BCA Design Assessment Report

SCEGGS Darlinghurst – Masterplan 2040
215 Forbes Street,
Darlinghurst

Project: SCEGGS Darlington – Masterplan 2040
 Document Type: BCA Design Assessment Report
 Report Number: P218_153-2 (BCA) LS

PROPOSED MASTERPLAN | WILKINSON LEVEL 2

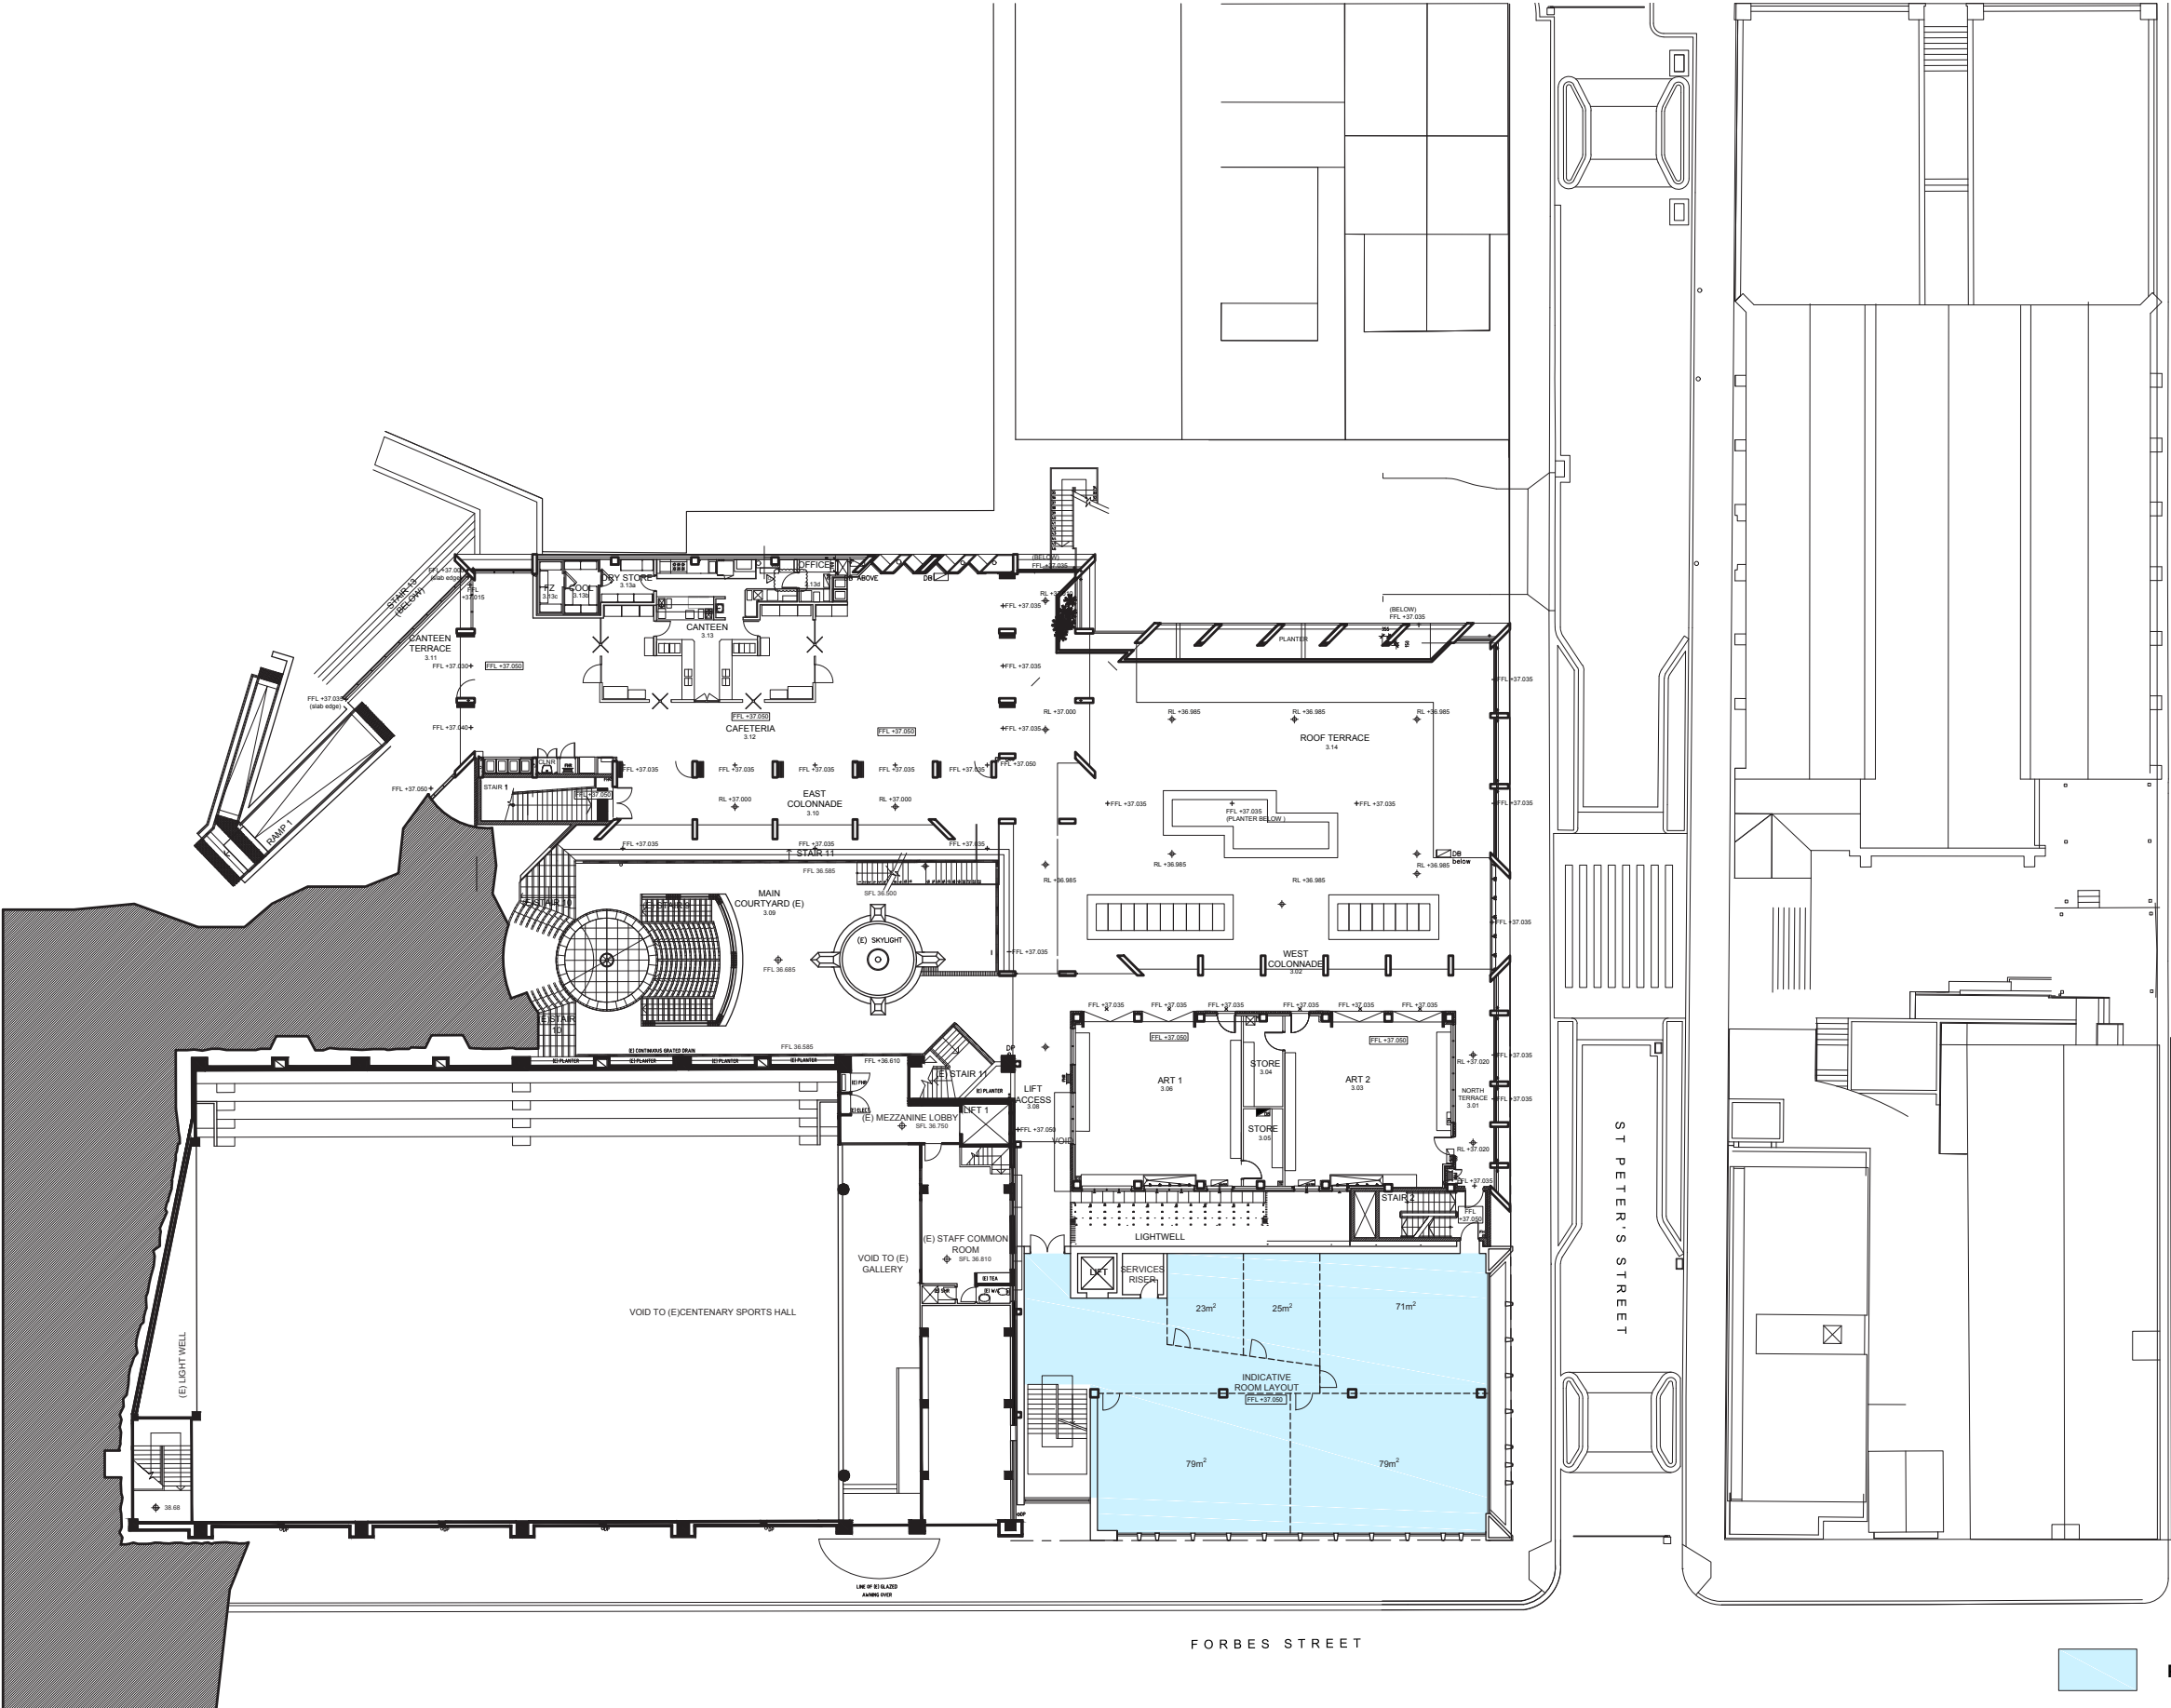
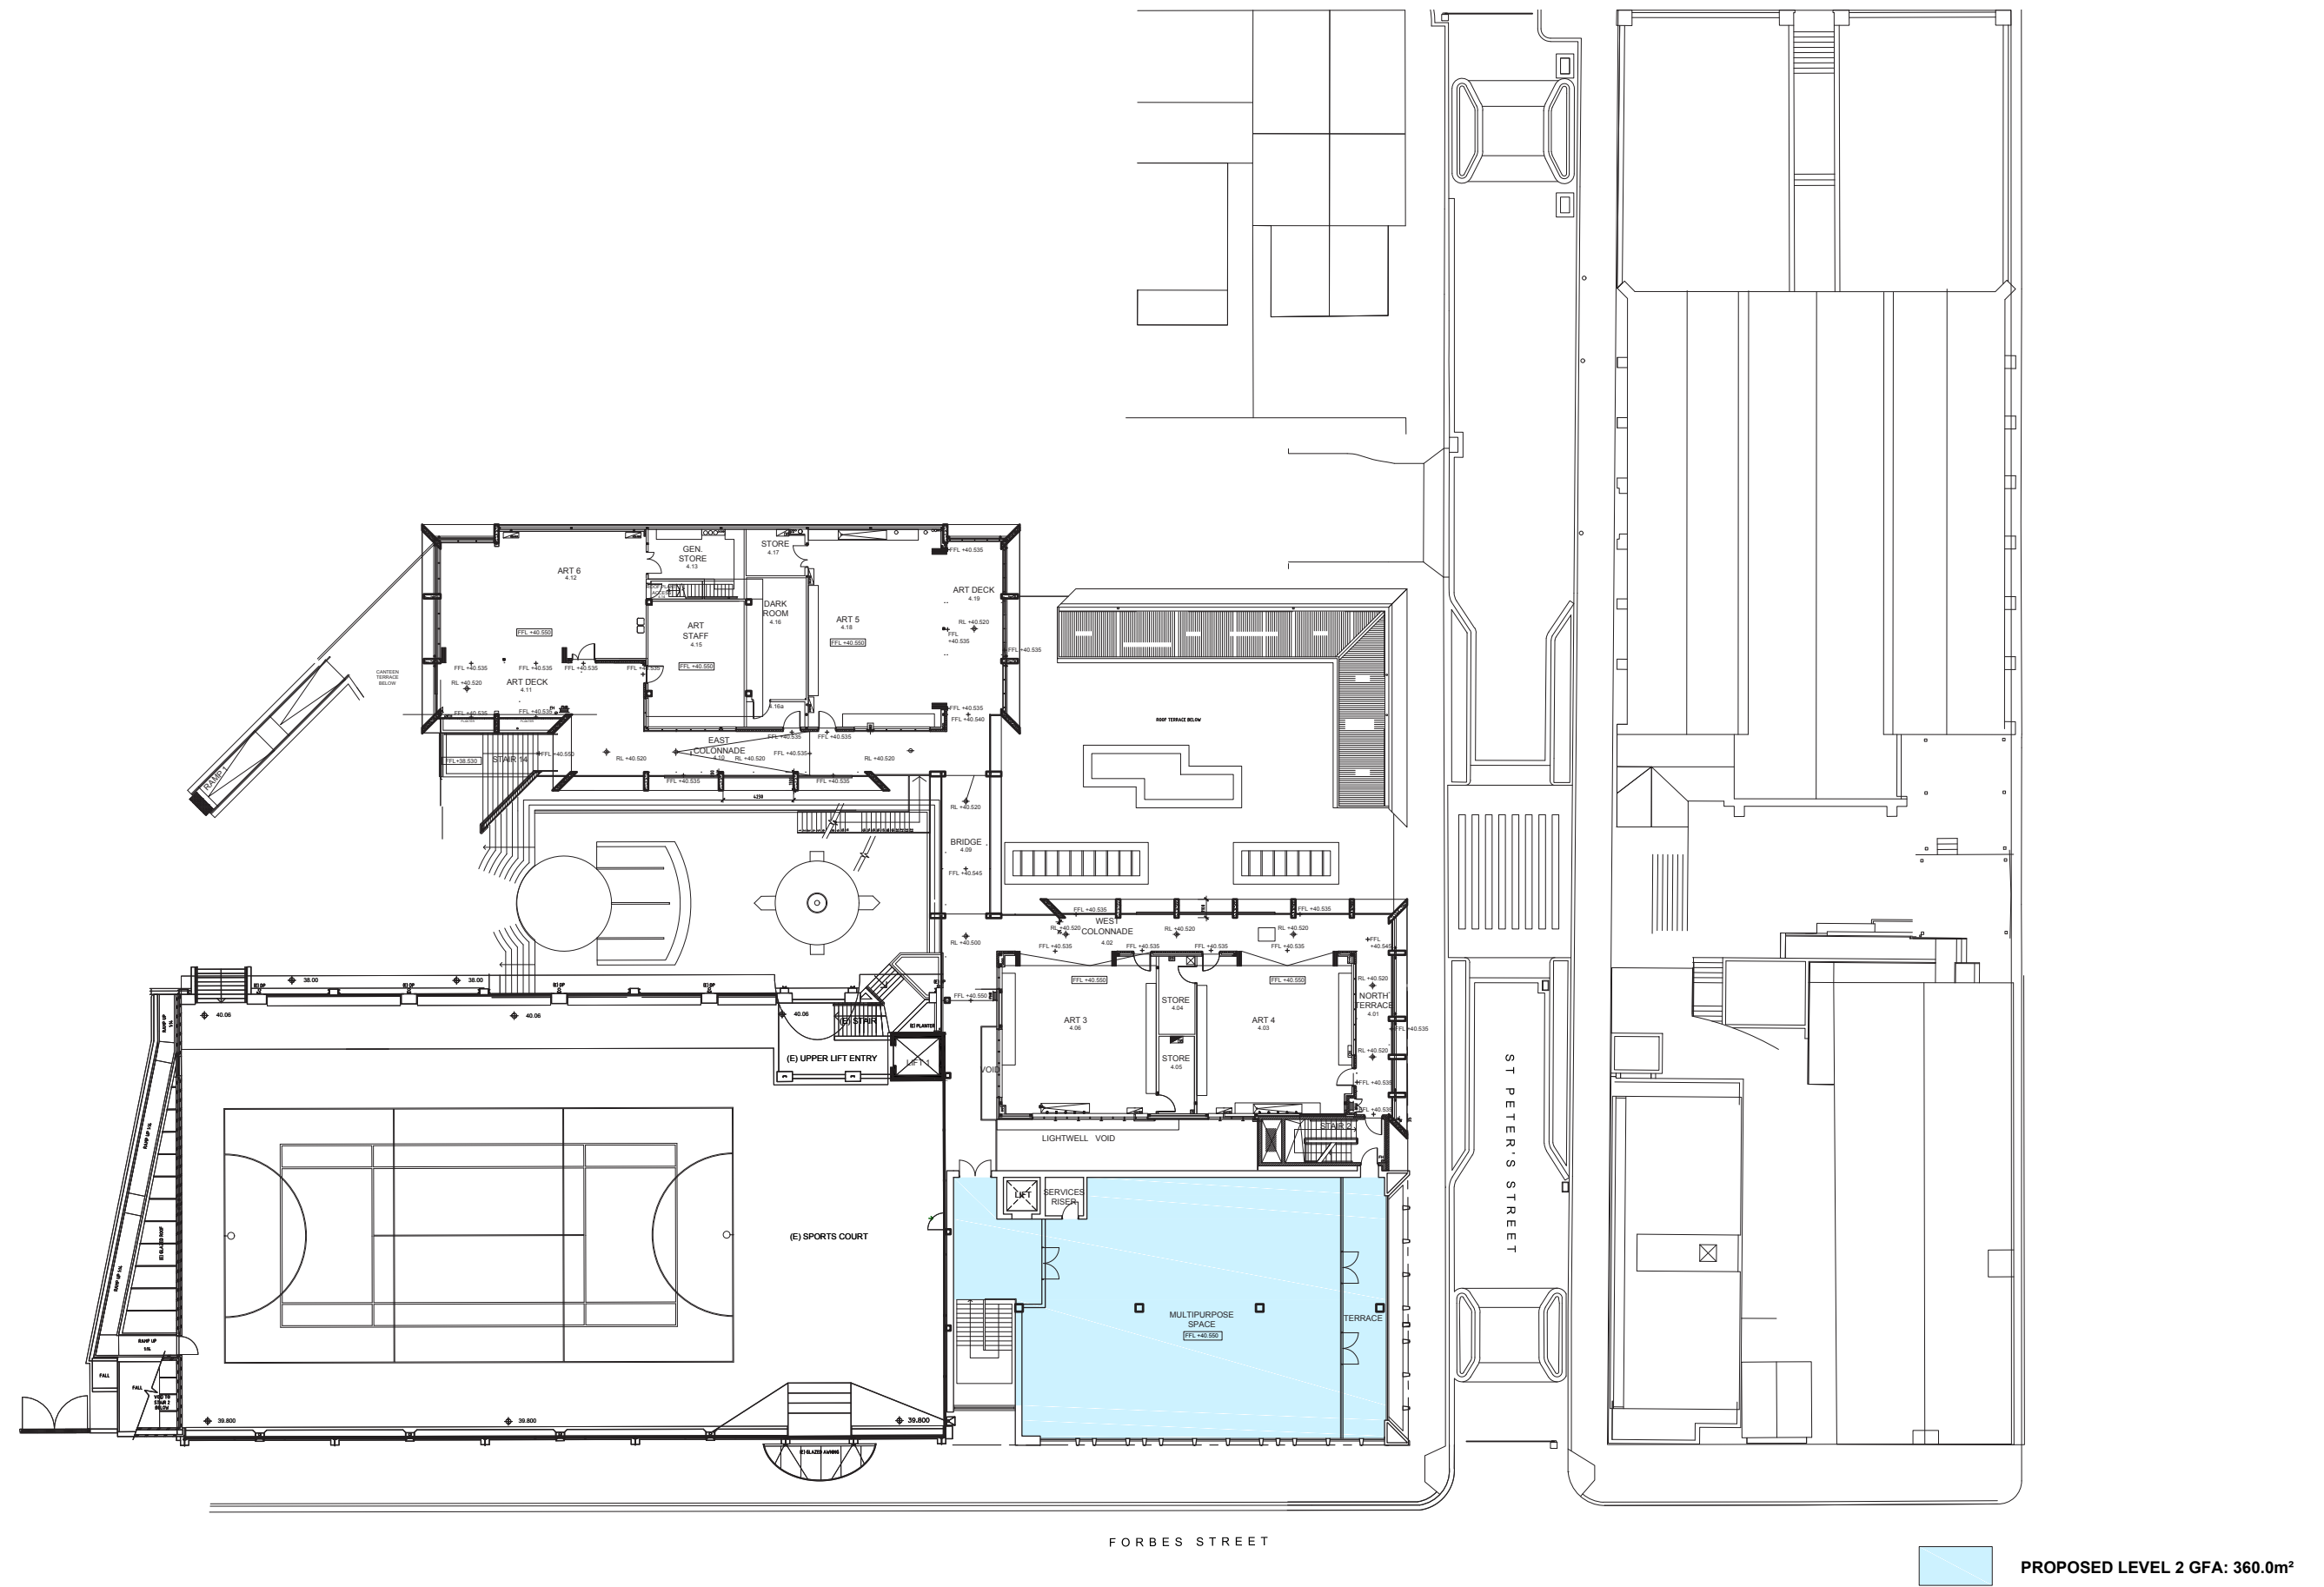
Cl. C2.2	To ensure the subject building is within the maximum floor area and volume limitations prescribed within C2.2, the building is to be separated from the adjoining building known as a the Centenary Sports Hall.
-------------	--

Compartmentation is to occur at every level, refer to Figure 1 below.

C2.7	<p>As stated in C2.2 above a fire wall needs to be introduced at all levels the buildings share a common wall or the like.</p> <p>Be advised that the DTS requirements of the BCA require the subject wall shown in Figure 1 to be constructed as follows –</p> <ul style="list-style-type: none"> (i) The passive / solid walls located between the two compartments is to achieve an FRL of not less than 120/120/120 and extend uninterrupted from the slab to slab; (ii) The doorway / opening which permits persons to pass through is to via a self-closing fire-rated doorsets that is tested to achieve an FRL of --/120/30
C2.10	<p>The lift shafts are required to achieve an FRL of 120/120/120 or --/120/120 (if non-loadbearing).</p>
C2.11	<p>The stairway and passenger lift proposed within the lobby connect five storeys (basement to level 3) and therefore are required to be fire-isolated and located in separate shafts.</p> <p>The proposal currently shows the subject stairway and lift in the same shaft and whilst the lift is located within a shaft which can be fire-rated appropriately the stairway is not enclosed / fire-isolated.</p> <p>The stairway design is discussed further in clause D1.3, however the current design may be capable subject to a performance based approach be adopted.</p>

C3.5	<p>As discussed in C2.2 and C2.7 above a fire wall needs to be introduced at the lower ground floor level to divide the building into two separate compartments and any opening located within this wall is be a self-closing fire door which achieves an FRL of --/120/30.</p>
C3.10	<ul style="list-style-type: none"> (i) The doorways providing access to the lift shaft shall be protected by --/60/-- fire doors complying with AS1735.11-1986 and remain closed except when discharging or receiving passengers or goods; and (ii) Any lift call button, indicator panel or other panel located within the wall of the fire-isolated lift shaft must be backed by construction having an FRL of --/60/60 if it exceeds 35,000mm² in area.
Cl. C3.12	<p>Where a service passes through a floor required to achieve an FRL, that service is required to be protected by either a shaft which has been construction in accordance with BCA Spec C1.1 (listed above) or in accordance with C3.15 (see below).</p>
